**Re: Tumble Creek Phase 3 Division 14
Preliminary Plat, LP-18-00002 and BLA, BL-18-00007**

New Suncadia, LLC is submitting this letter in response to the transmittal of comments received for the Suncadia Phase 3, Division 14 Preliminary Plat and BLA project. Below you will find responses to the comments. Let me know if you have any questions.

**Re: Tumble Creek Phase 3 Division 14
Engineering Plan Submittal**

**NEW SUNCADIA LLC
 PHASE 3 DIVISION 14
 COMPOSITE UTILITY PLAN**
 WASHINGTON
 KITTITAS COUNTY

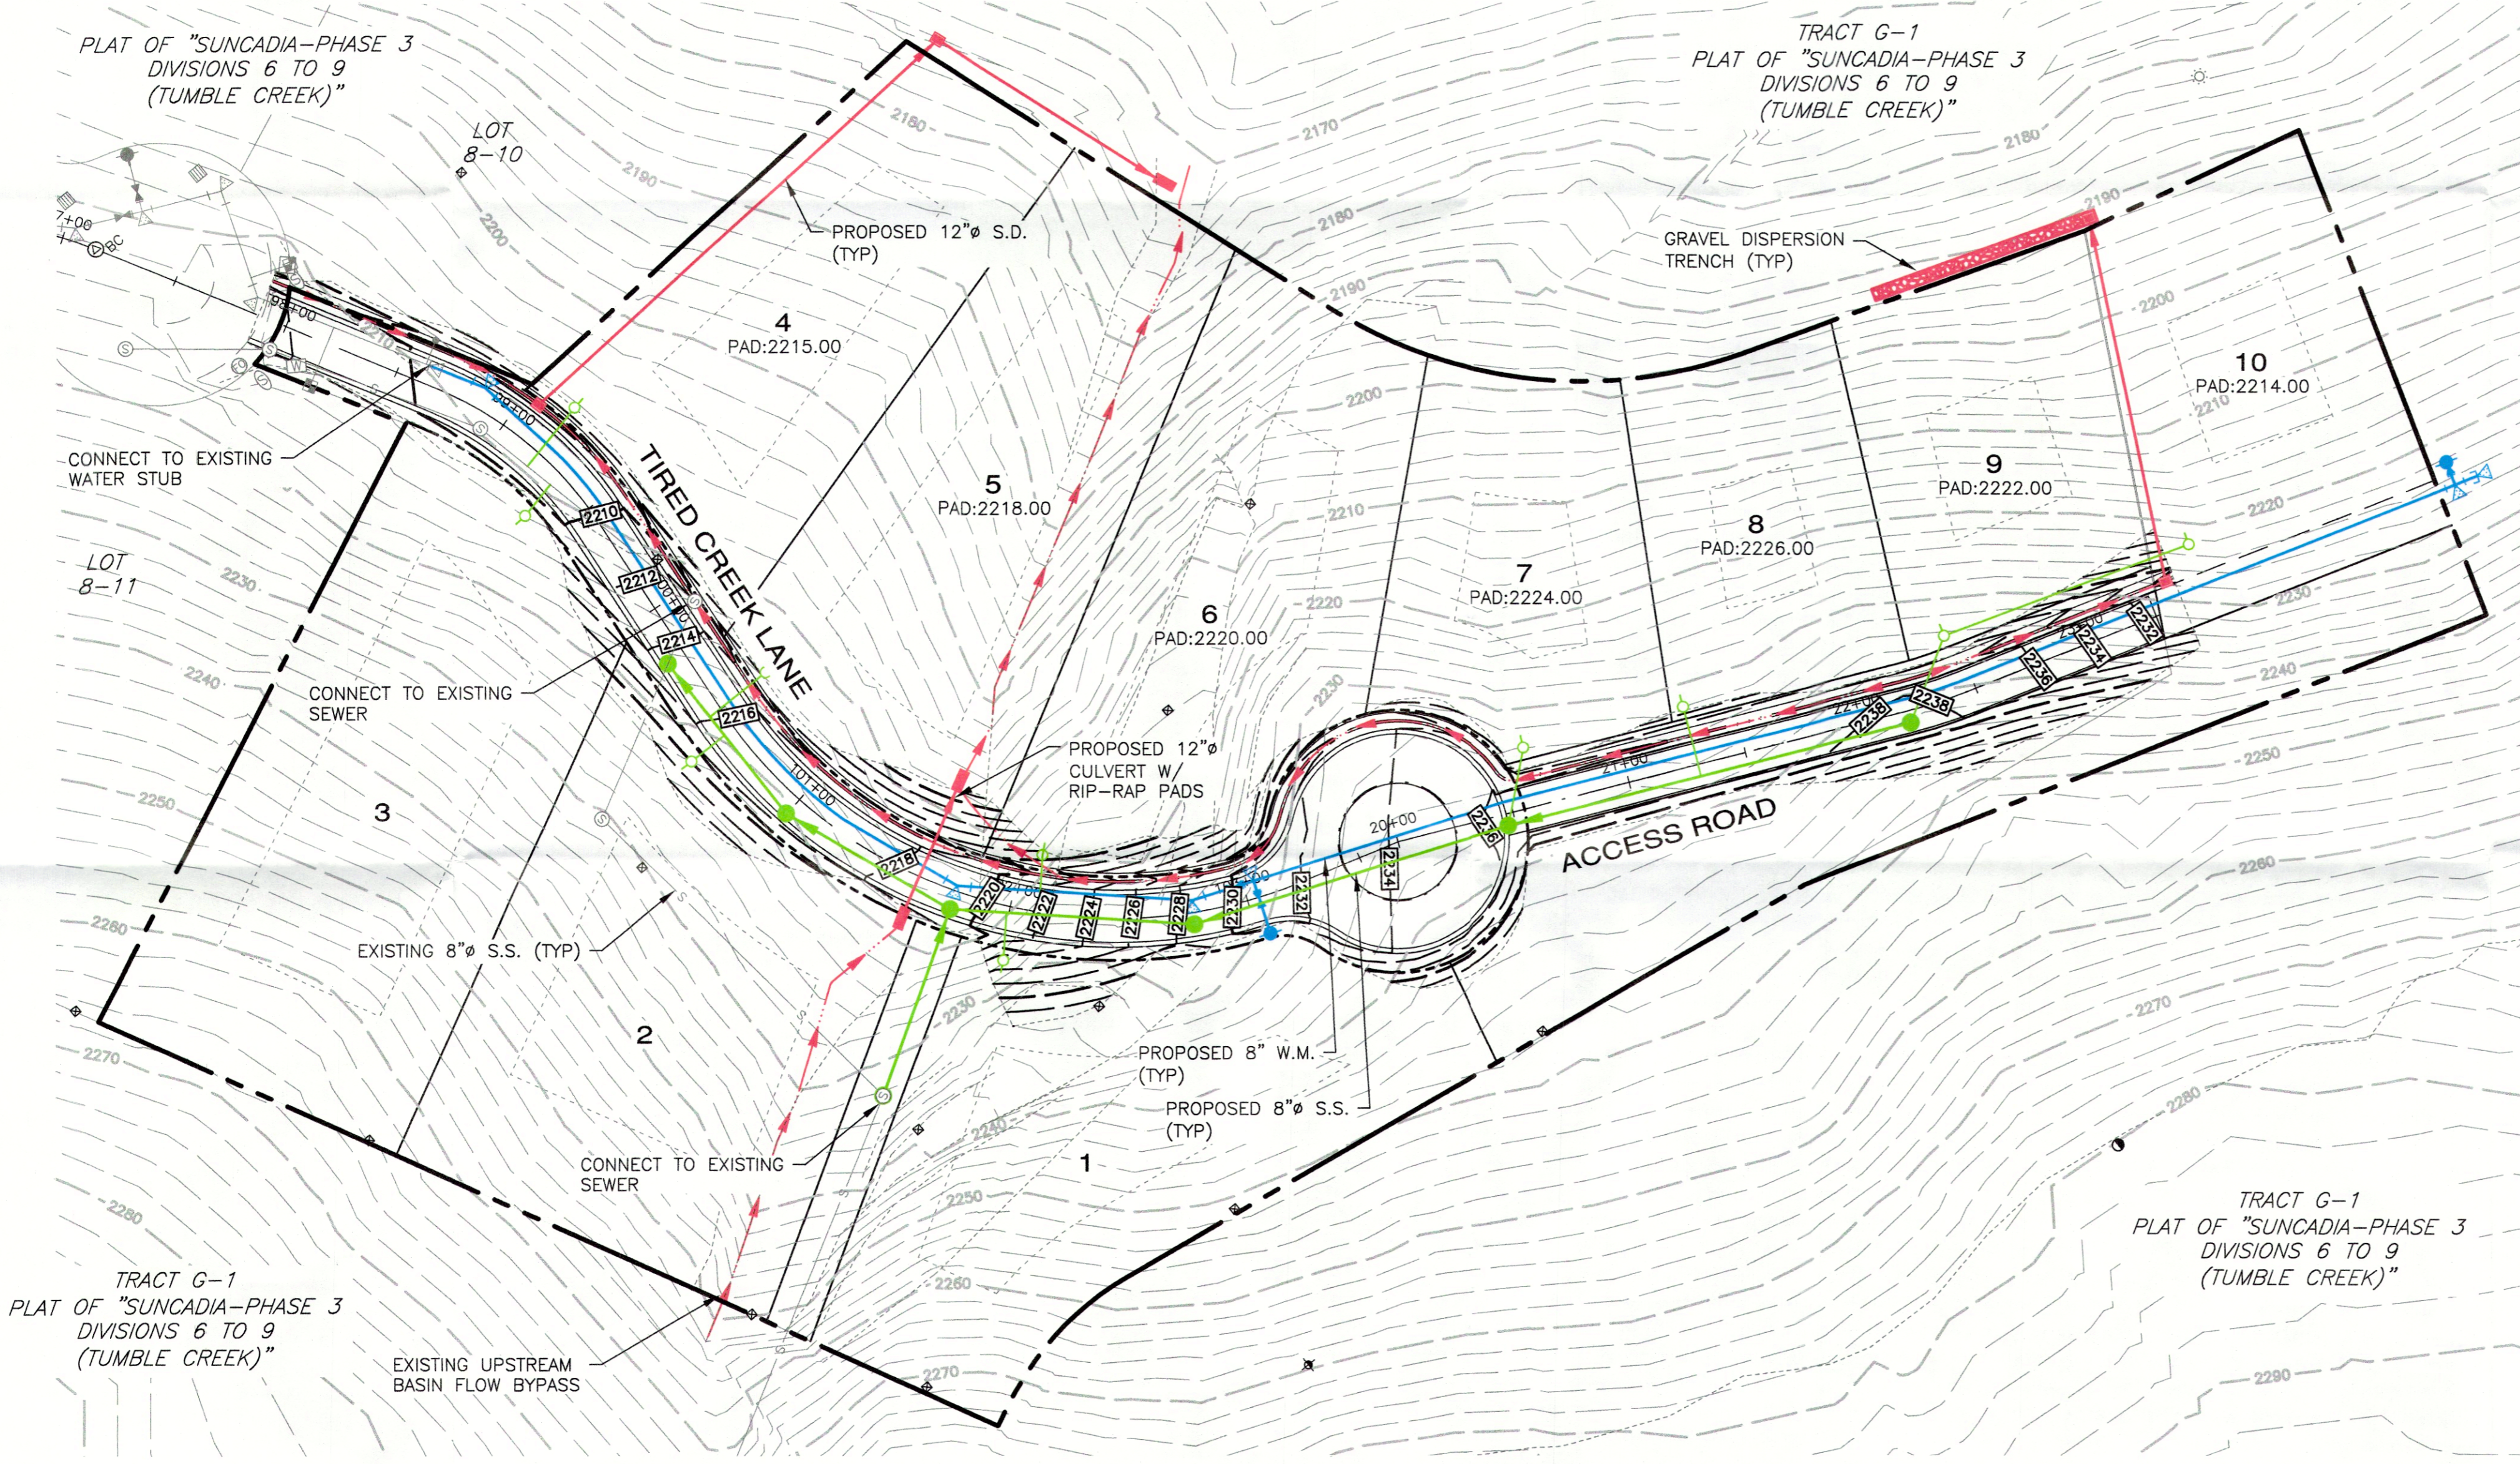
4. *It appears that the sanitary sewer (8 inch) connects westerly to Phase 3 Divisions 6 to 9. Please verify that all sewage flows are gravity flows from Phase 3 Division 14.*

The assumption is correct, and the gravity sewer information is shown on the attached construction plans. Some lots may require grinder pumps if they are constructed below specific pad elevations.

Site Development Plan Phase 3 Division 14 Tumble Creek July 18, 2018

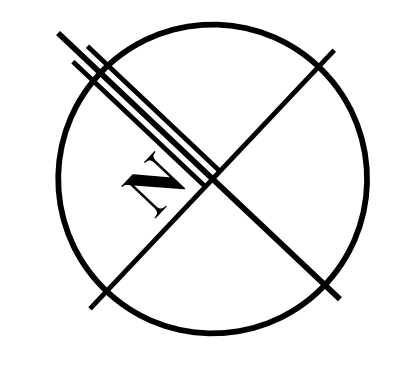
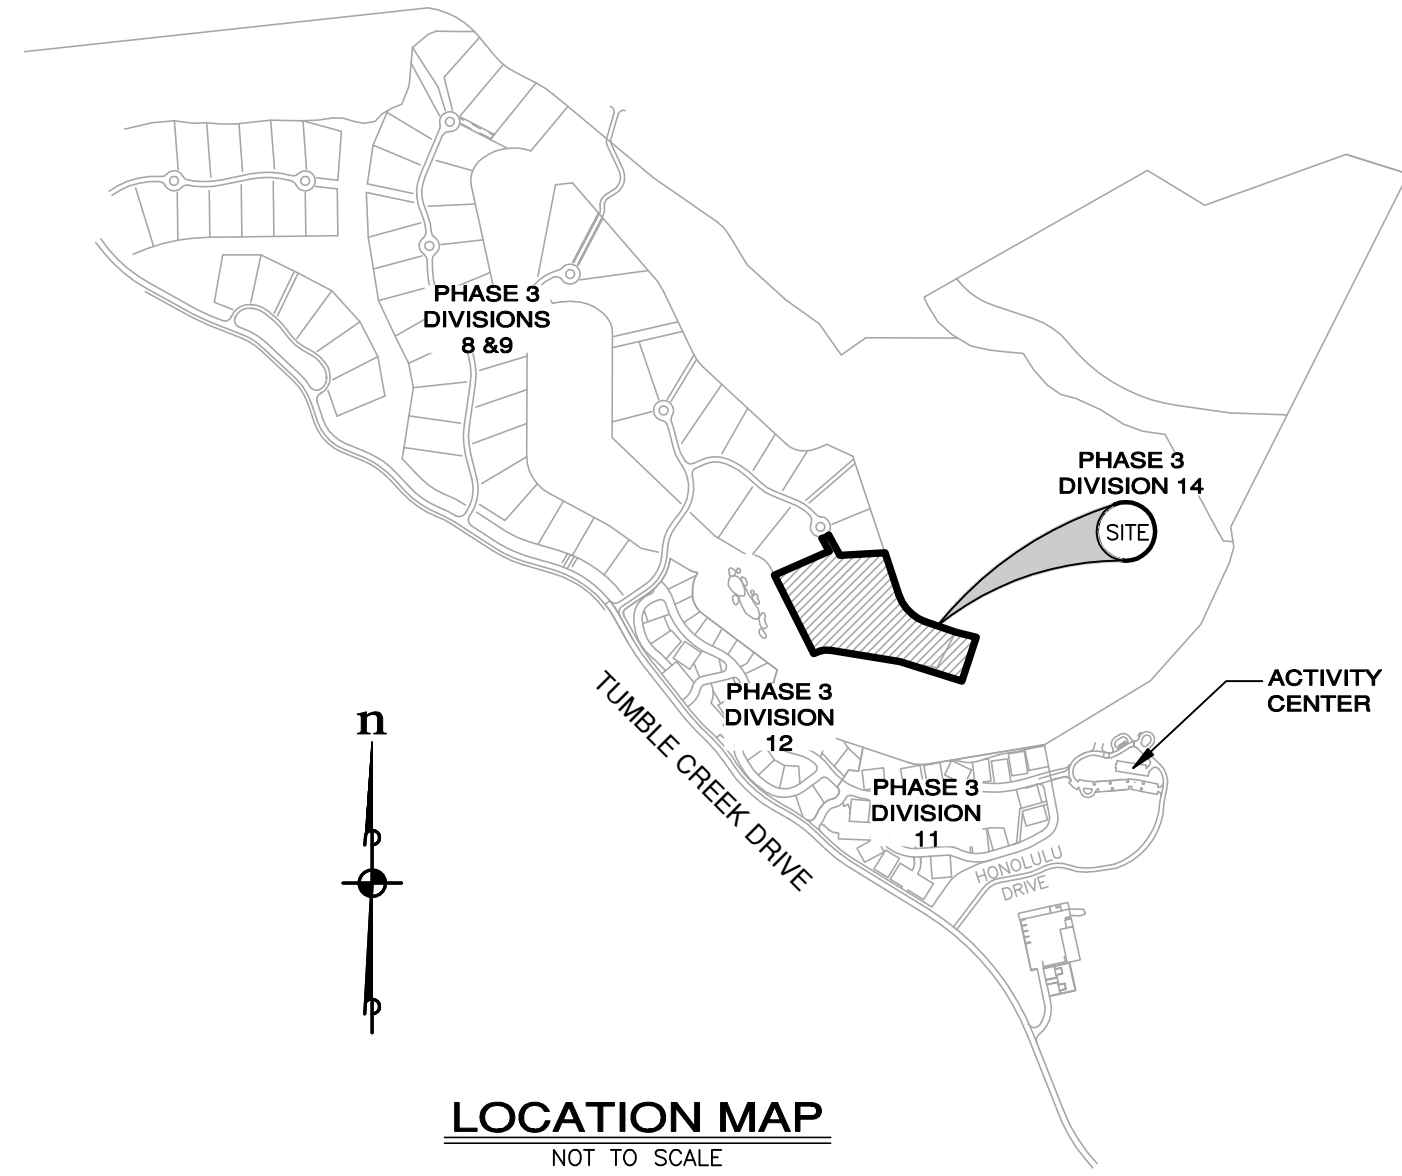
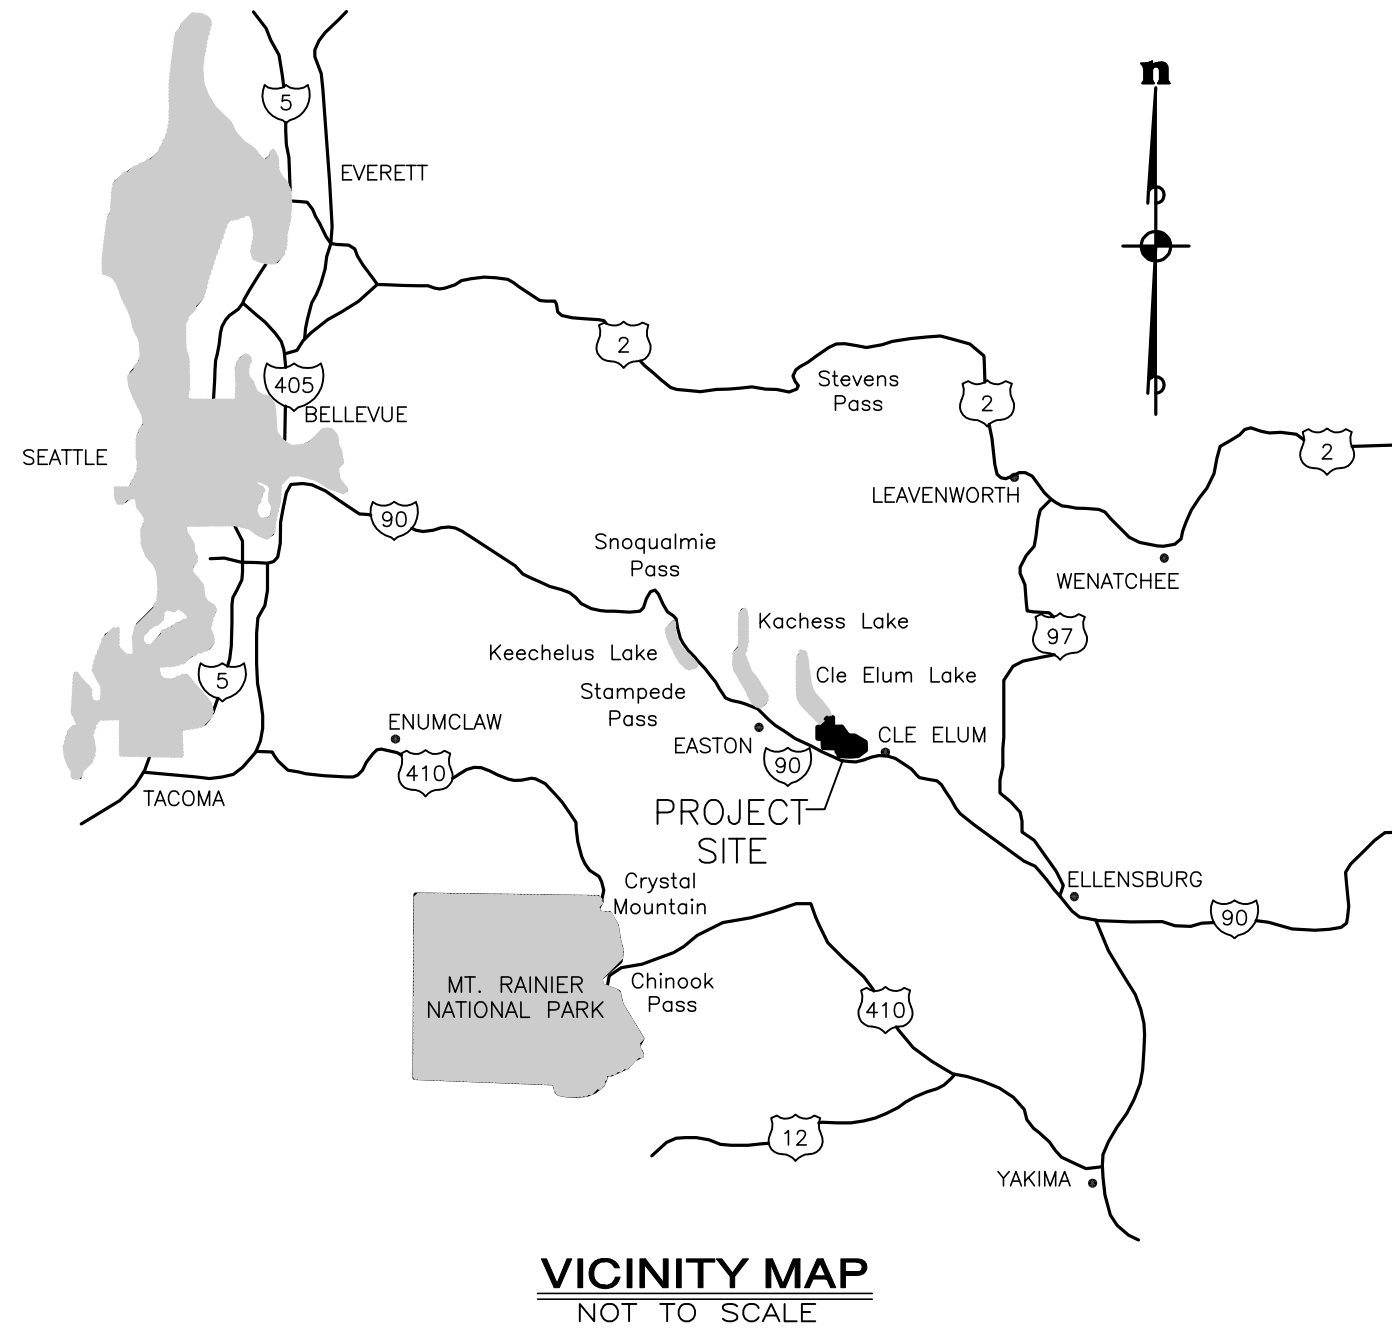
To the extent the Site Development Plan (the "SDP") drawing may not have shown the building envelopes, it has been updated. The SDP includes more than just the site plan, and the SDP narrative indicates that parking is to be on the lots. The Suncadia design guidelines restrict parking on lots to building envelopes and driveways, and Exhibit J to the Development Agreement only requires that building envelopes be shown. See Design Guideline Section 2.9 Garages and Parking. On lot parking is not a county review item, nor is compliance with the Suncadia design guidelines.

JOB NO.:	998-722-017
DWG. NAME:	PP-03
DESIGNED BY:	JJH
DRAWN BY:	LGB
CHECKED BY:	
DATE:	03/19/2018
PRINT DATE:	
SHEET	
PP-03

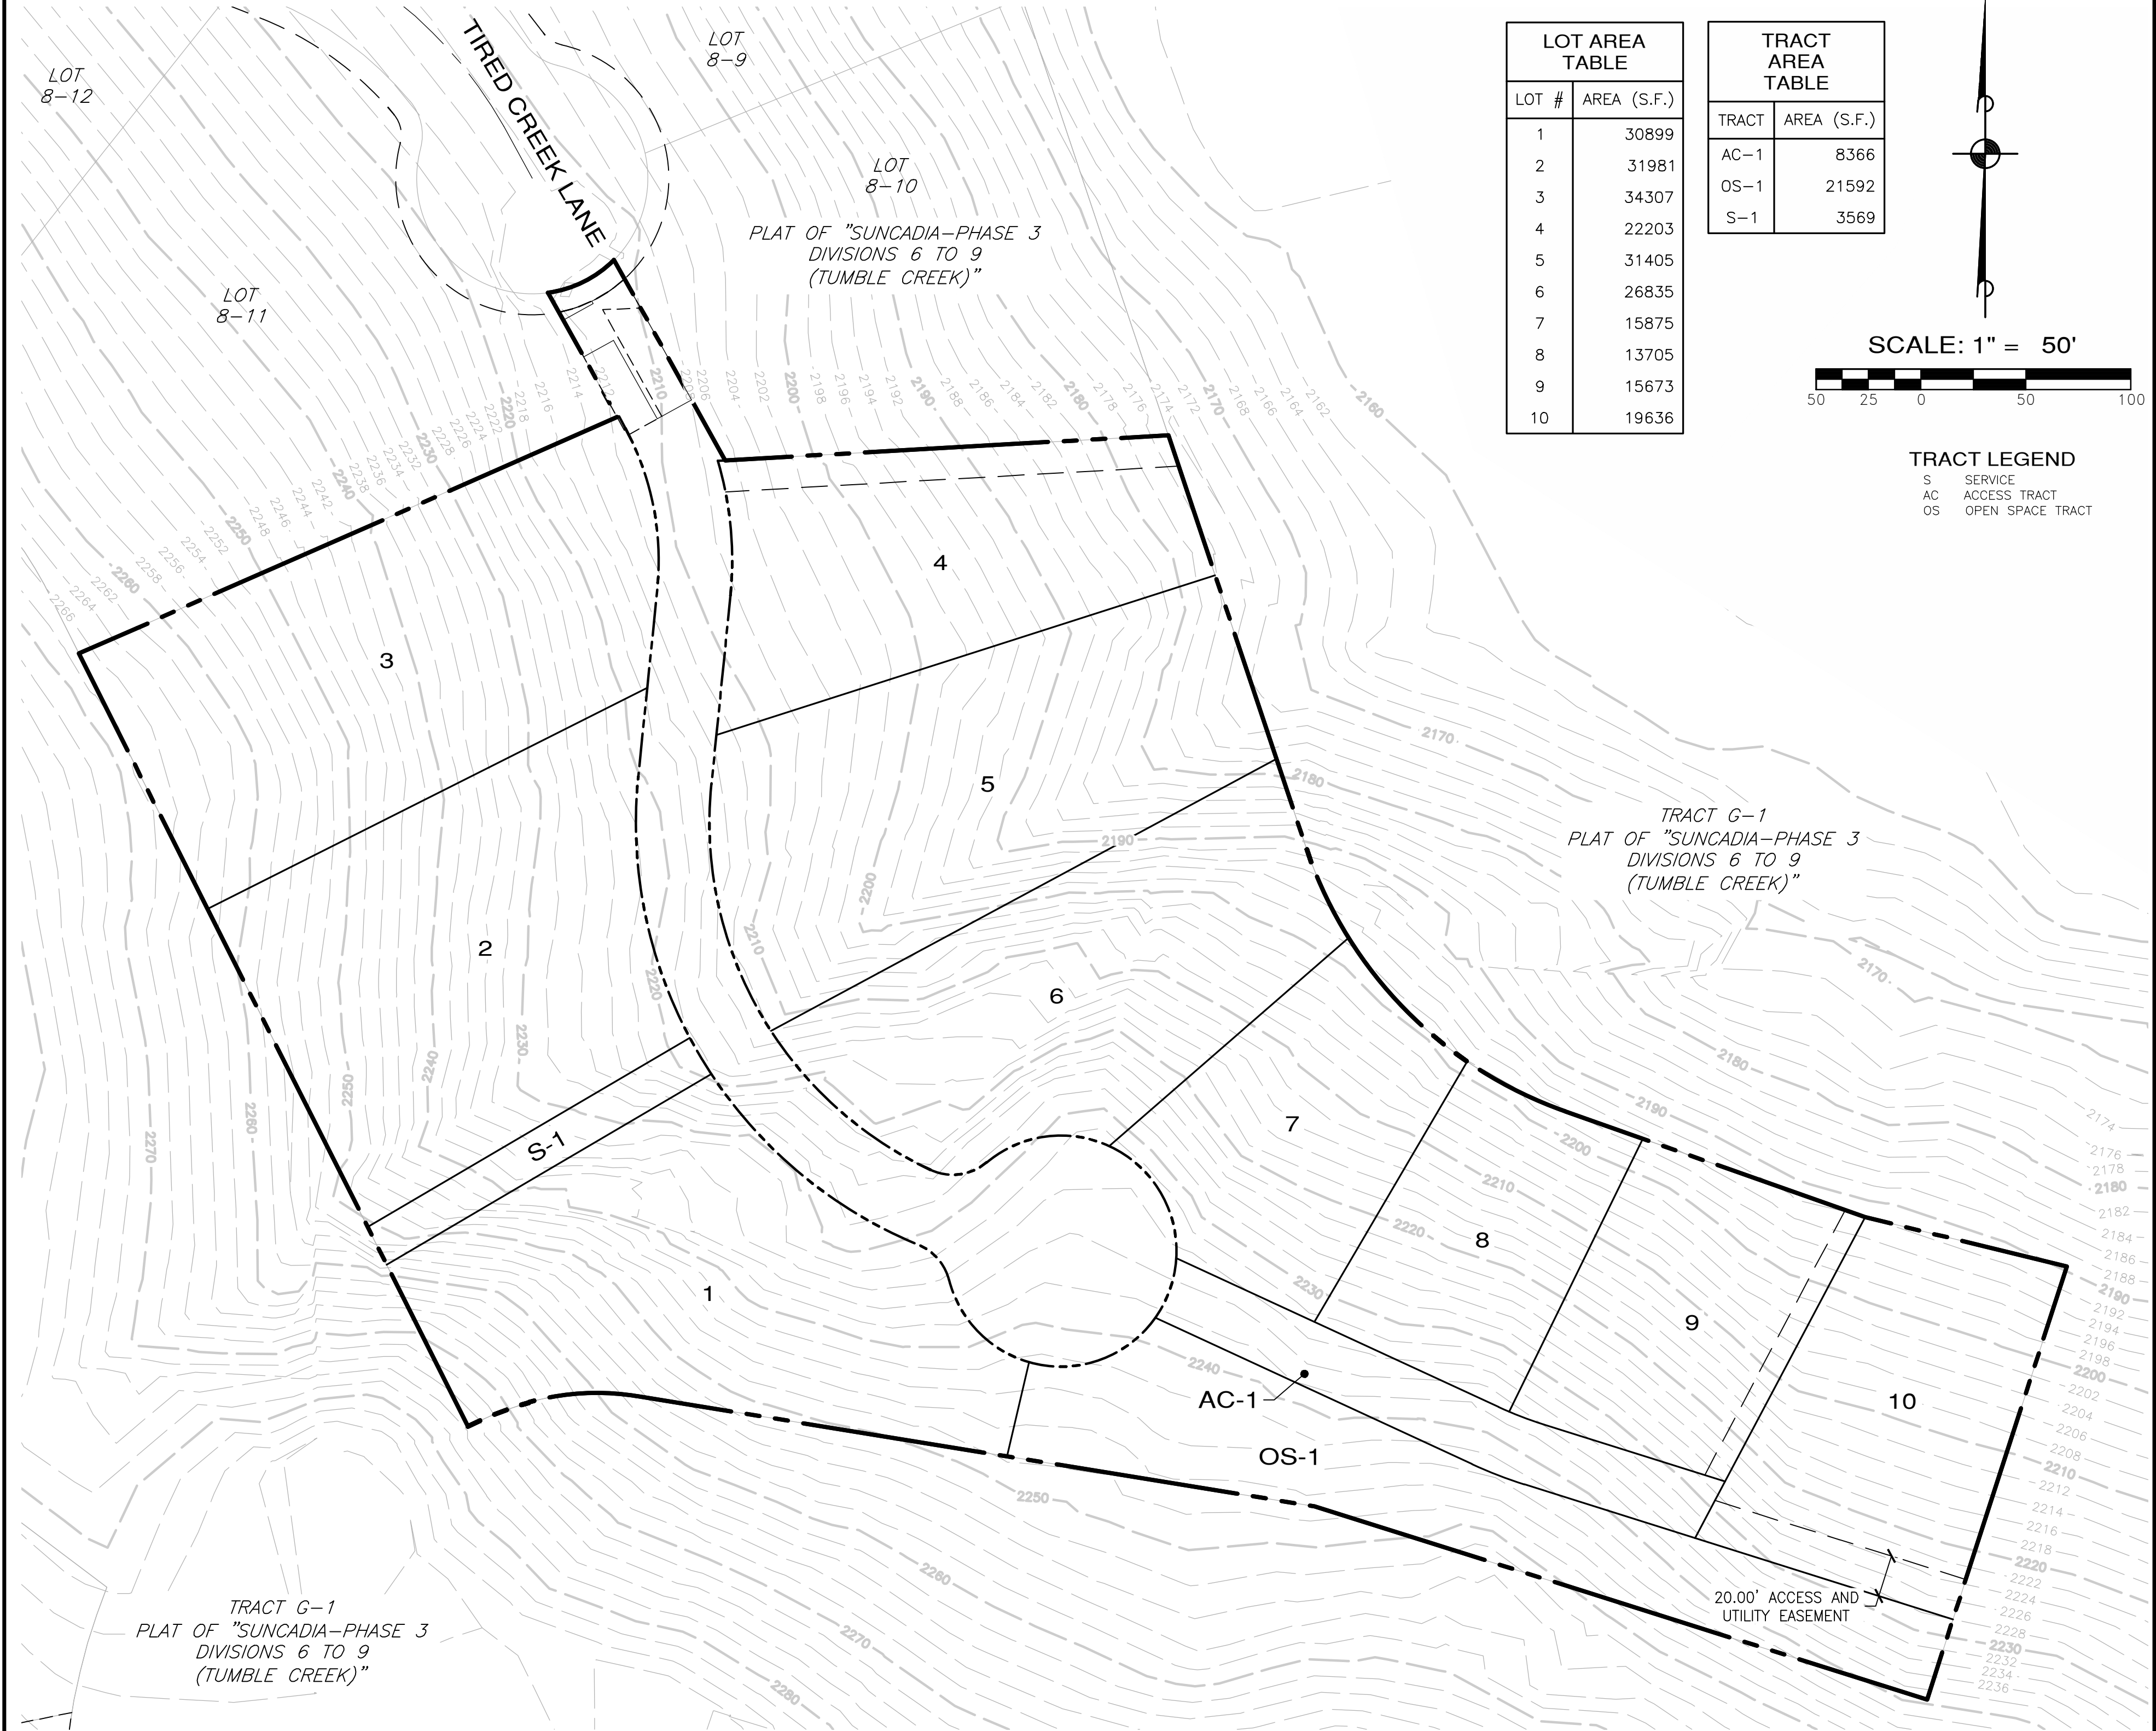
Lot area table will be amended to include S-1, AG-1, and OS-1
